## **ATTACHMENT A – SUMMARY OF RECOMMENDATIONS**

*This document 'Attachment A' contains a summary of Councils' recommendations relating to the State Significant Development Application for the Telopea Stage 1A and Concept Plan Application. It should be read in conjunction with Council's submission which was endorsed by Council at its meeting on 22 November 2021 and Attachment B Technical Assessment.*

Figure 3. Plan indicating extent of public open space and encroachment of basement.

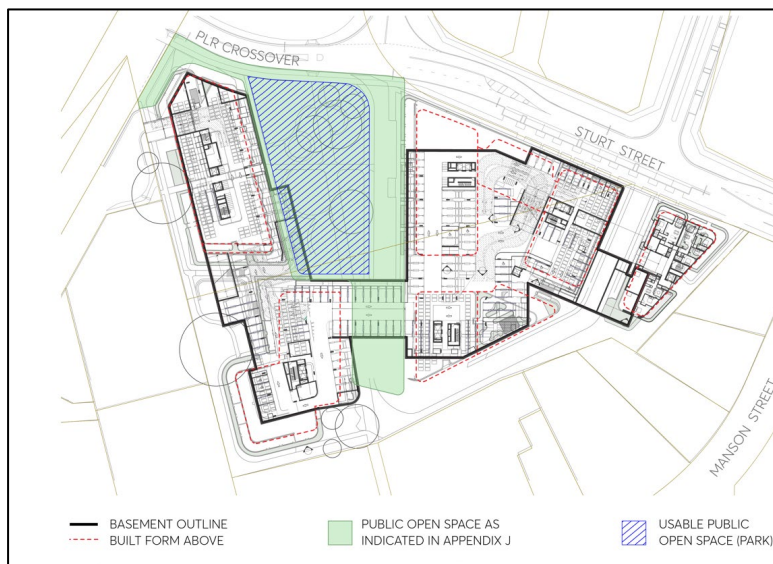
- 6.1 A plan of for all proposed open space to be dedicated to Council should be submitted which clearly indicates the extent of dedication to Council and aligns with the proposed subdivision plan, landscape and basement plans. All

open space to be dedicated to Council shall demonstrate that there is no basement encroachment.
